FLOOR PLAN

APPROVED
Limited building only review
Permit holder responsible for full compliance with the code

CRAWFORD RESIDENCE

PLAN NO.
CRAWFORD

ROOF PLAN
SCALE: 1/4"=1'-0"

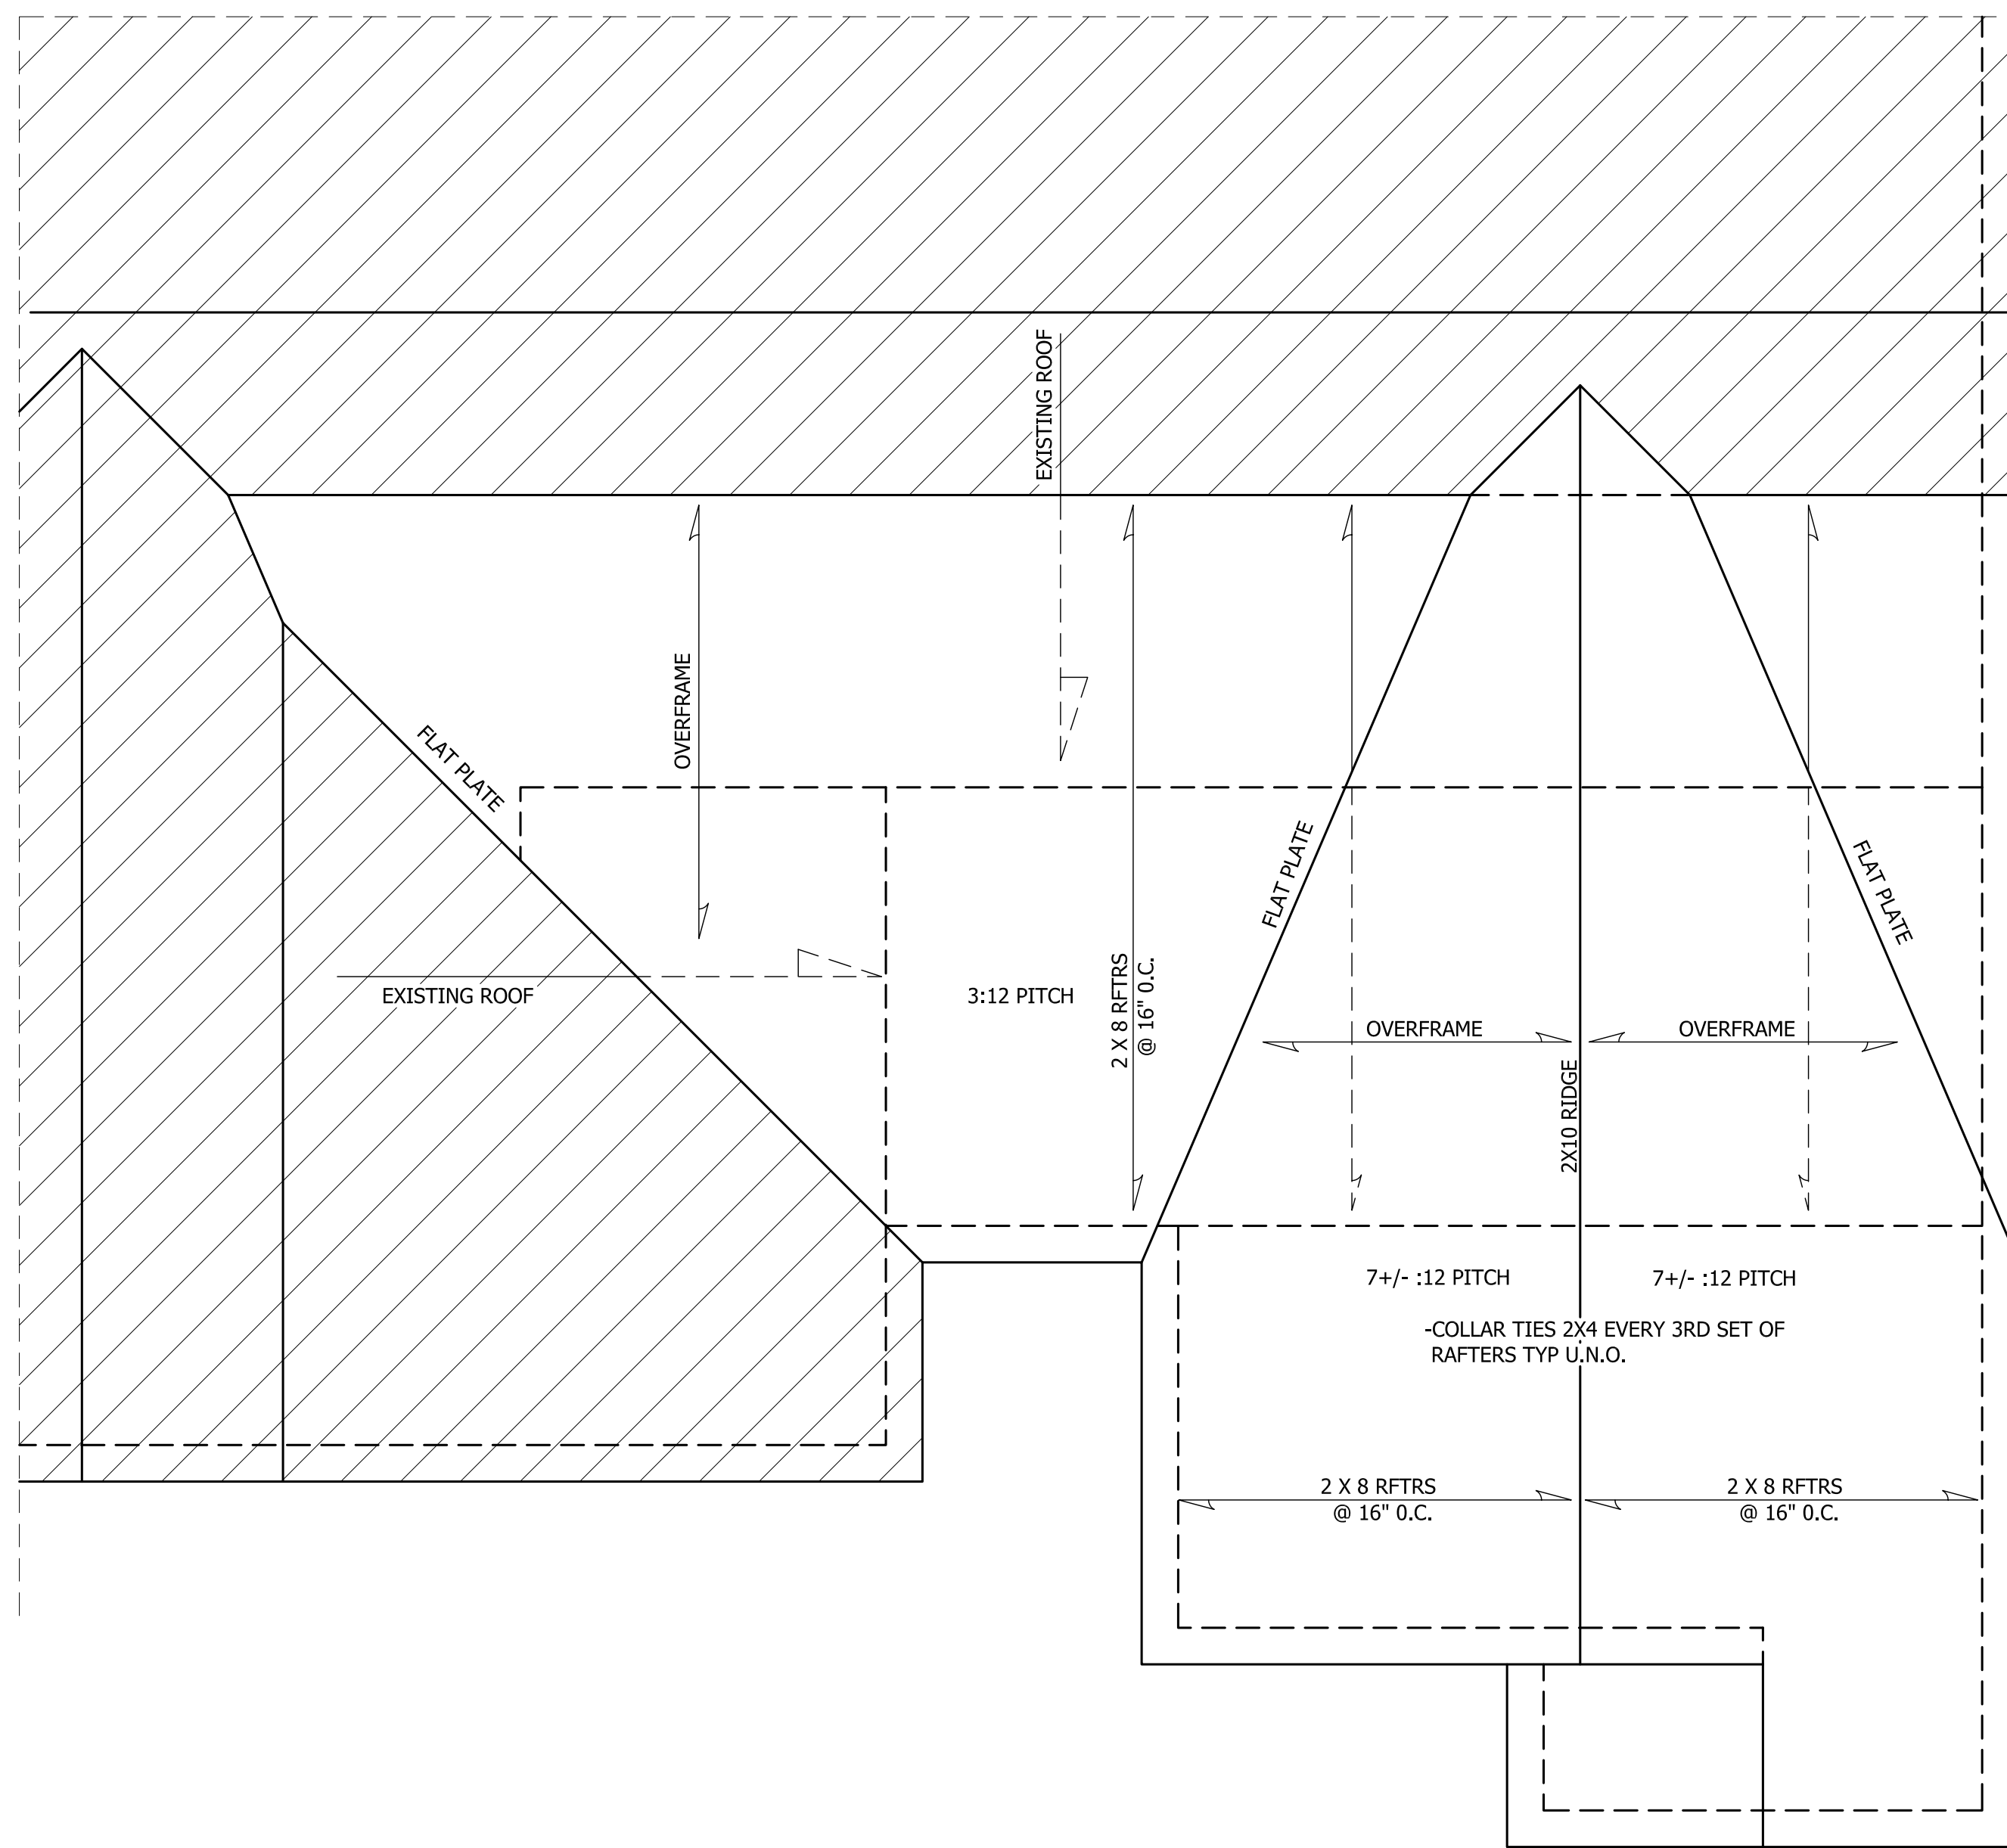
Provide ridge beam for cathedral ceilings, supported at both ends and designed to carry roof load
